DOC20/892962

Senders ref: SSD 10385 (Woollahra Municipality)

**Subject: Notice of Exhibition Kambala Sport, Wellbeing and Senior Learning Precinct, 794-796 New South Head Road, Rose Bay (SSD 10385)**

Figure 10 Maximum overland Flow generated by DRAINS Model for 1% AEP Event in Existing Condition

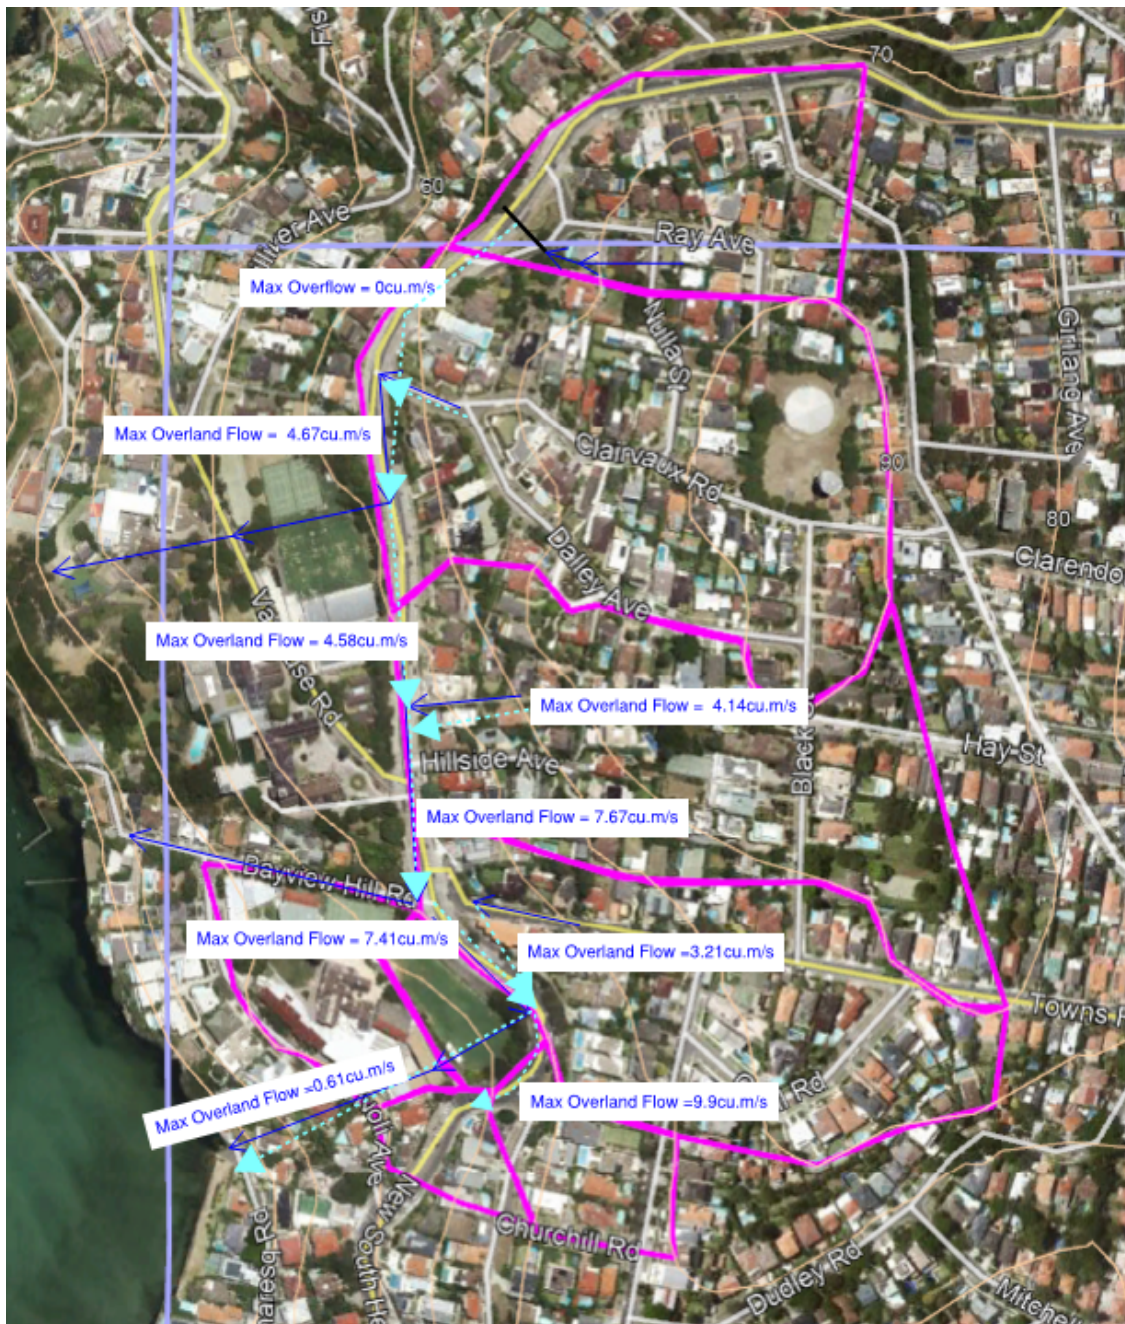
The Stormwater Management Plan states that the any overland flow on New South Head Road is assumed to remain on the road and bypass the subject site. Furthermore, the 2013 Rose Bay FRMS/P states in Section 4.4.1 – “It should be noted that design flood levels, extents and velocities were not determined in the upper catchment”.

Considering these assumptions, it is recommended that a more detailed flood assessment is undertaken of the upper Rose Bay sub catchment relevant to the subject site, to determine the level of flood risk from overland flooding into the subject precinct from the surrounding roads. The flood assessment should consider and assess the impact from the full range of floods (up to the probable maximum flood).
